Recommendation Report for Planning Permission for Works or Extension to a Dwelling

REF NO: FP/43/21/HH

LOCATION: 14 Felpham Way
Felpham
PO22 8QT

PROPOSAL: Side and rear extension.

Proposed Side & Rear Extension
Plans and Elevations
Planning
Date
March 2021
Scale
1:50

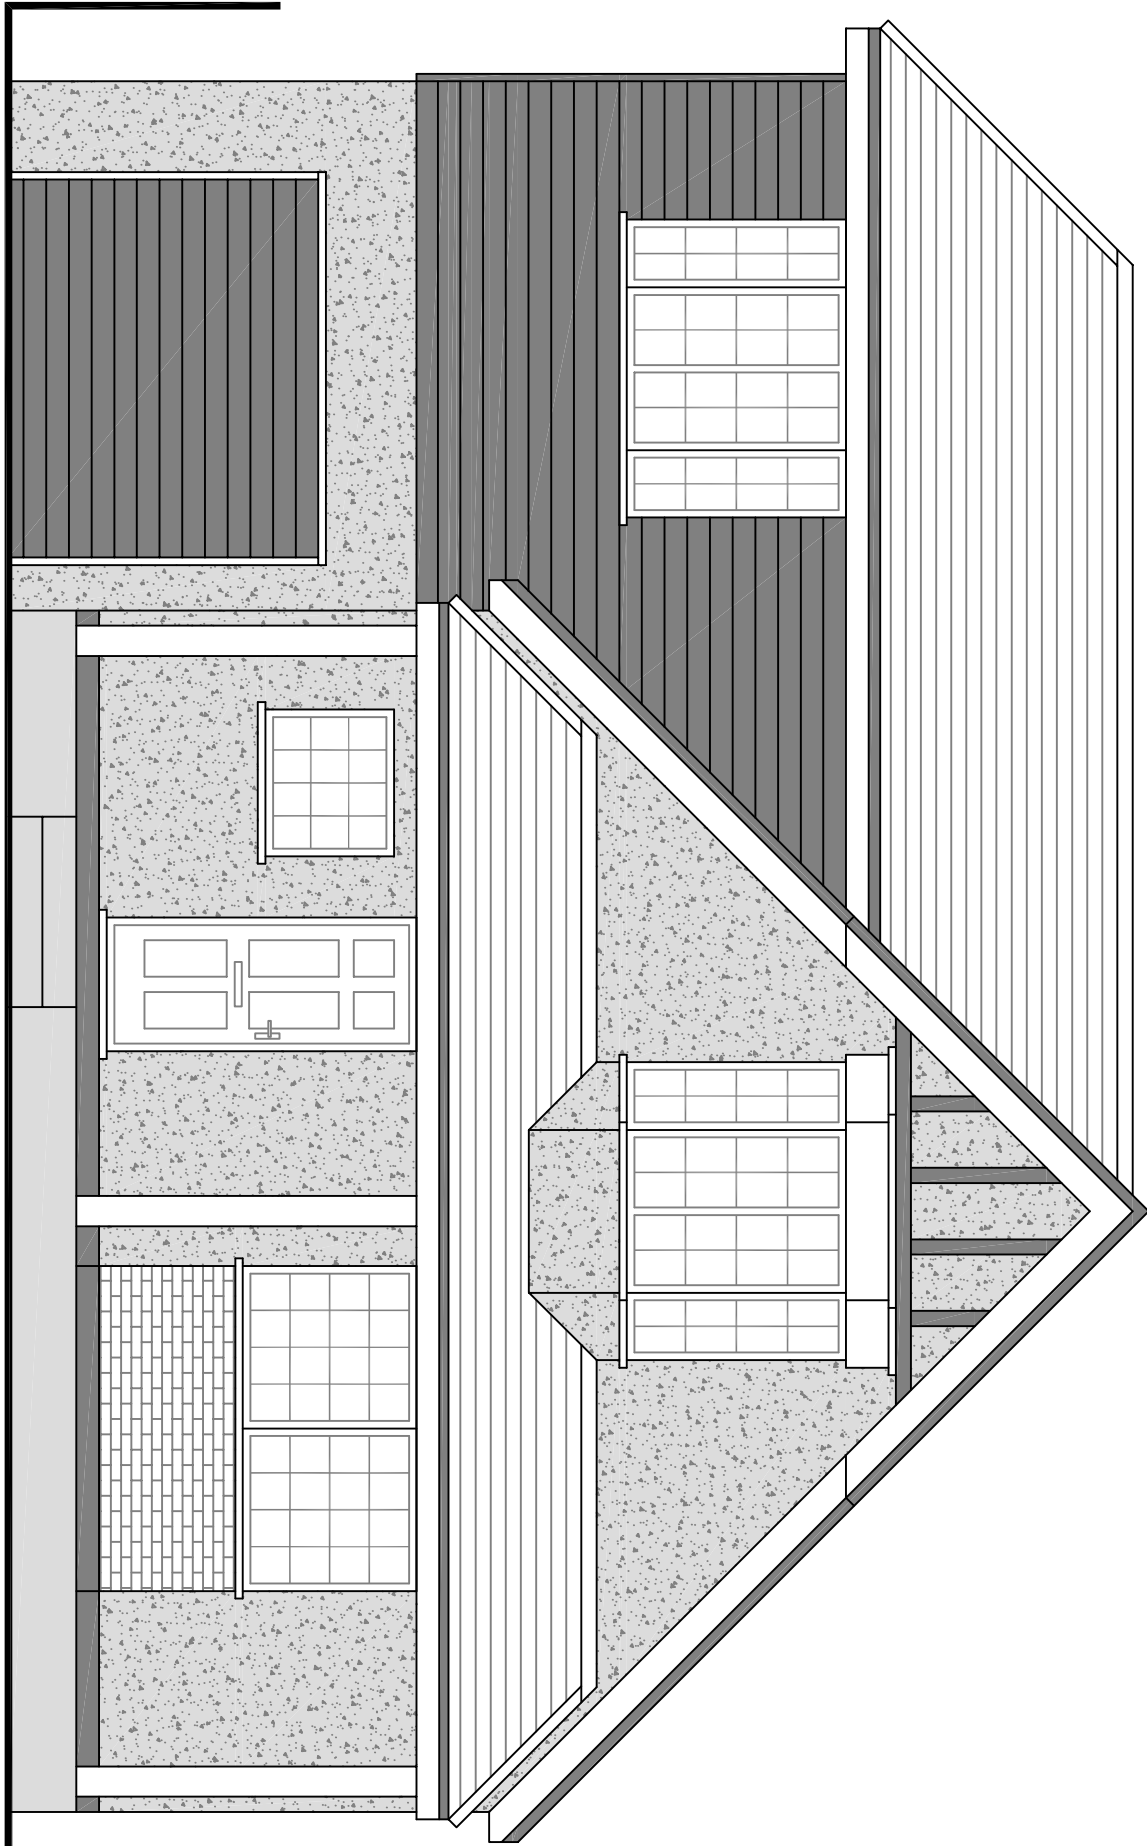
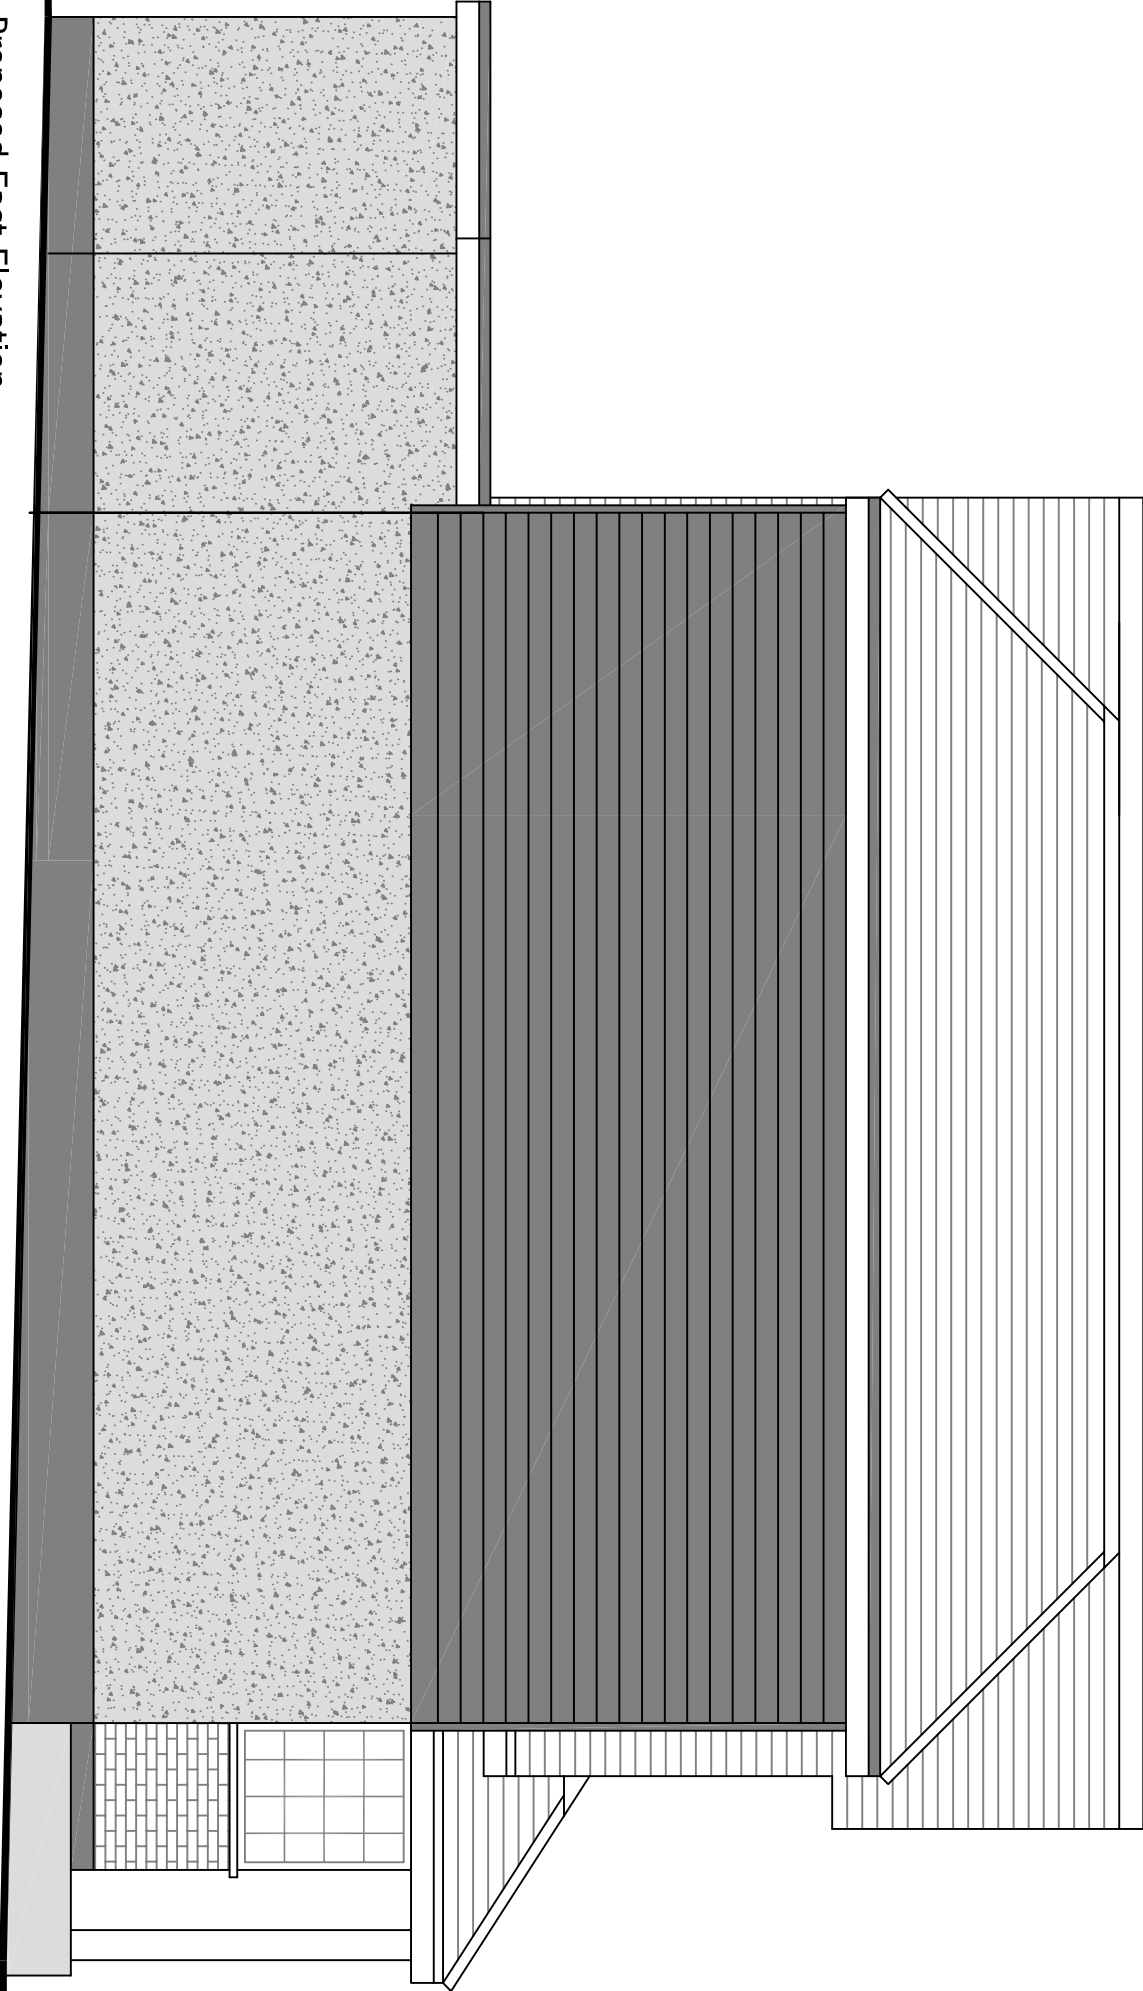
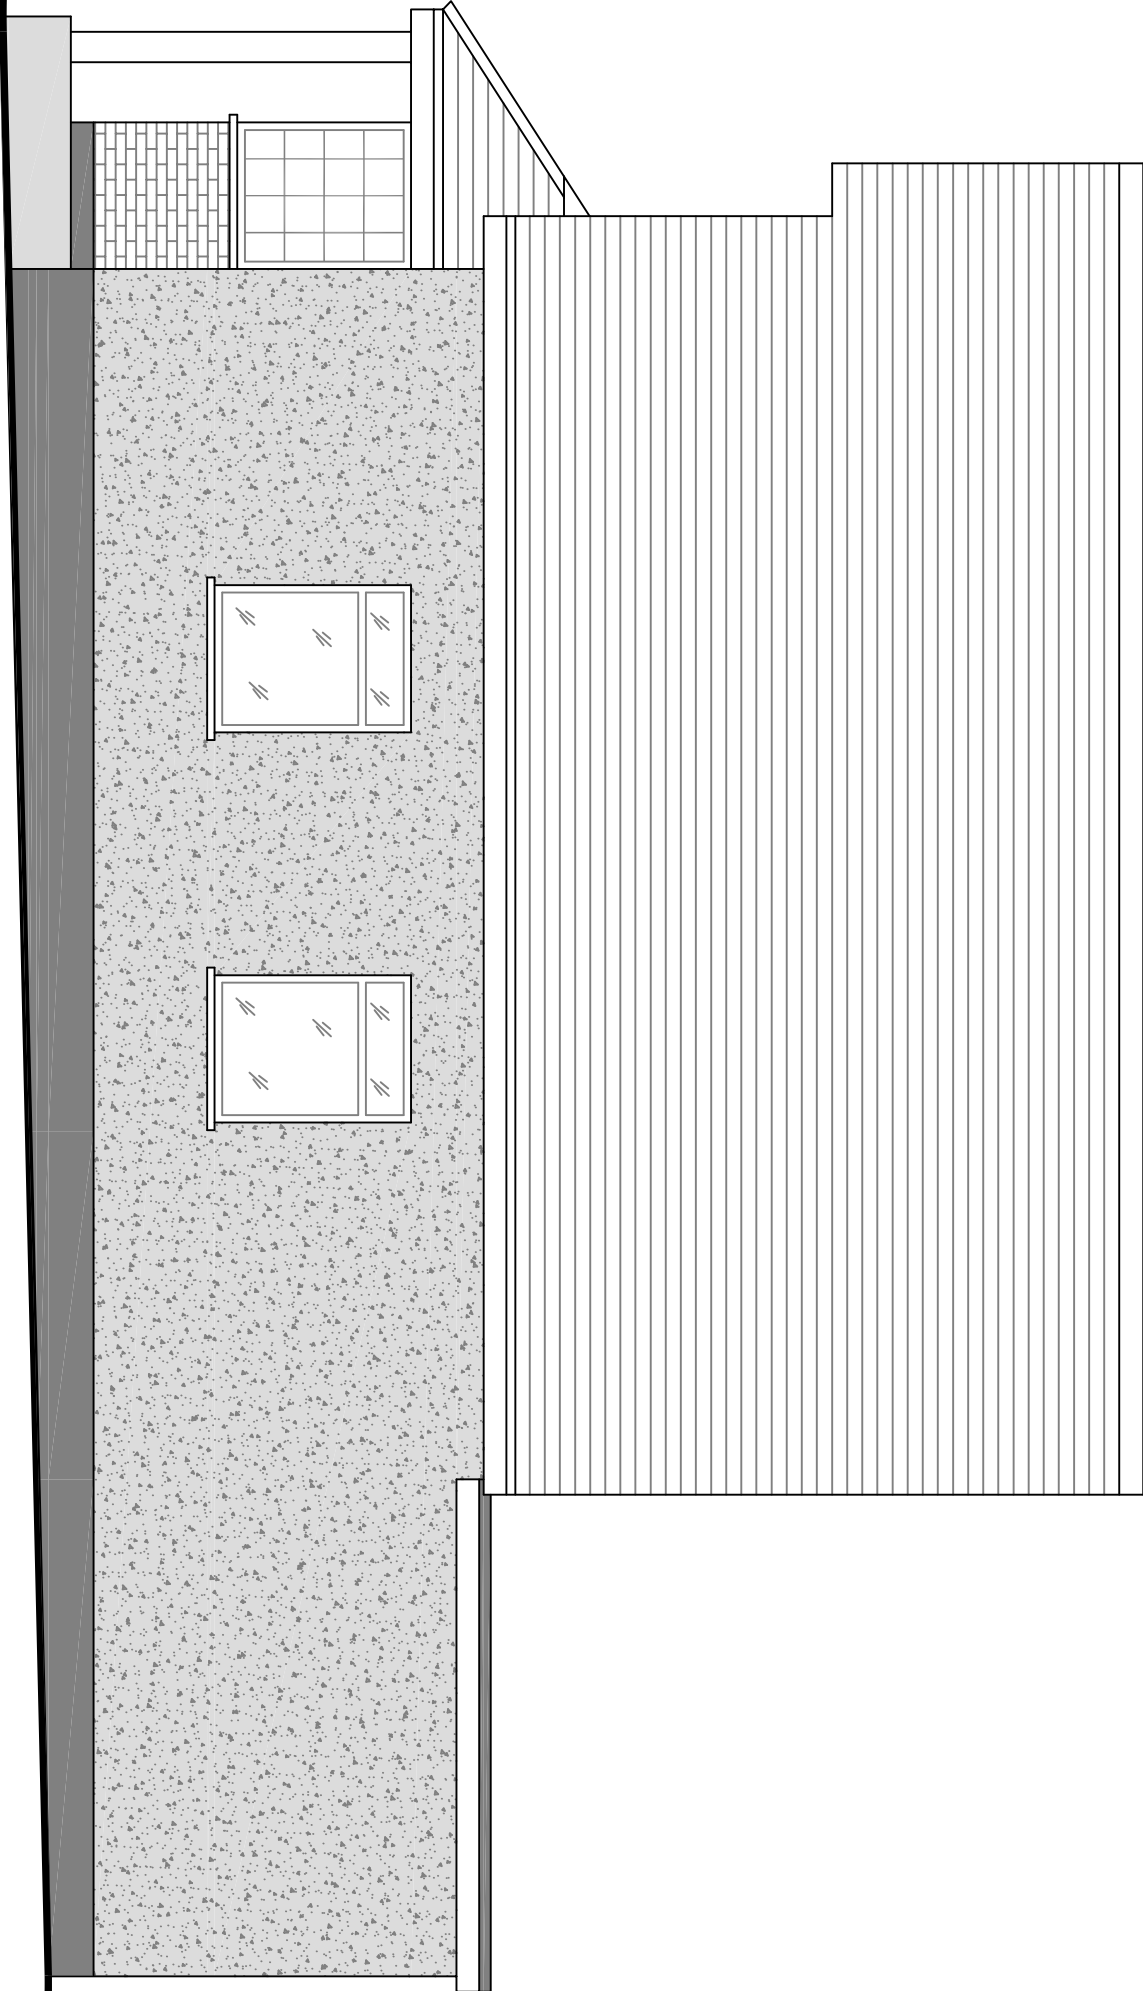
The addition at two storeys appears subservient to the host dwelling. It will have a hipped roof and run along the side elevation. The rear extension will be flat roofed at ground floor and will not be visible in the street scene. Materials will match the dwelling which helps to ensure it appears well integrated. As a whole the extensions will be in character with the surrounding dwelling houses and local area.

Section M of the Arun Design Guide outlines how household extensions should appear. The proposed extension would not comply with Section M as it would be built right up to the boundary instead of leaving a 1m gap and the extension would not comply with a 70 degree rule. In addition the extension would not be set back 1m from the principle elevation however no harm is considered to be caused by the development as demonstrated in the next paragraph and therefore non compliance with part M is not considered to warrant a refusal of this application.

The extension will be two storeys in height running along the side boundary of the property within the building lines of the existing property with a ground floor projection at the rear running across the rear of the dwellinghouse

The neighbouring property does not have a sole primary habitable room windows facing the side elevation of the extension. It has an obscure glazed bathroom window which is not considered to be significantly adversely affected by the new extension.

The addition is also not considered to intersect a 45 degree angle when drawn from the nearest ground floor window at the neighbouring property.
